Application no: H16/0033/00

Description: Extensions and alterations to
accommodate new staircase to
second floor.

Amendment: Parapet wall removed. Windows altered to equal sizes.
Dwg. No. 99/56/01B and 02A

ACKNOWLEDGEMENT OF AMENDMENT

99/56/02 A

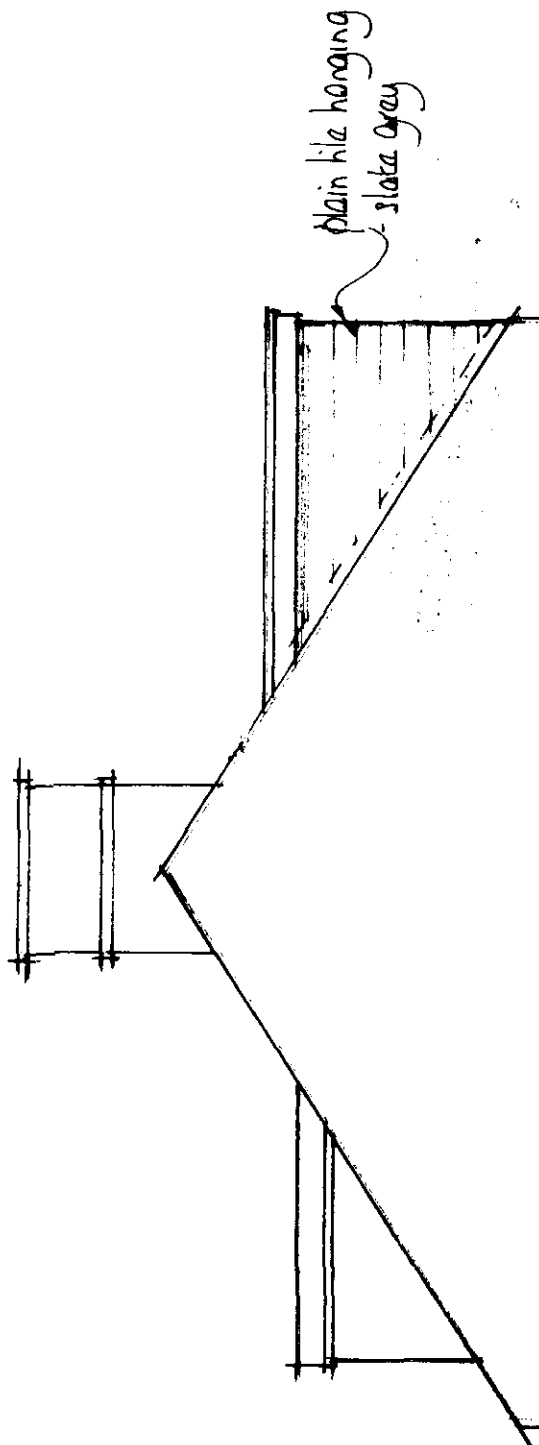
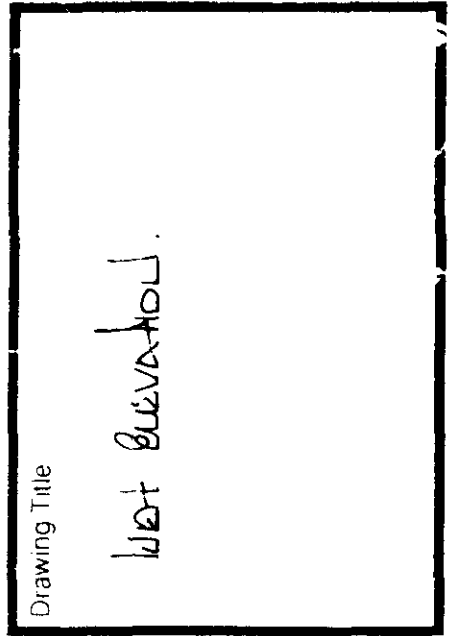
PORCHET WALL REMOVED.
 WINDOWS ALTERED TO
 EQUAL SIZES.
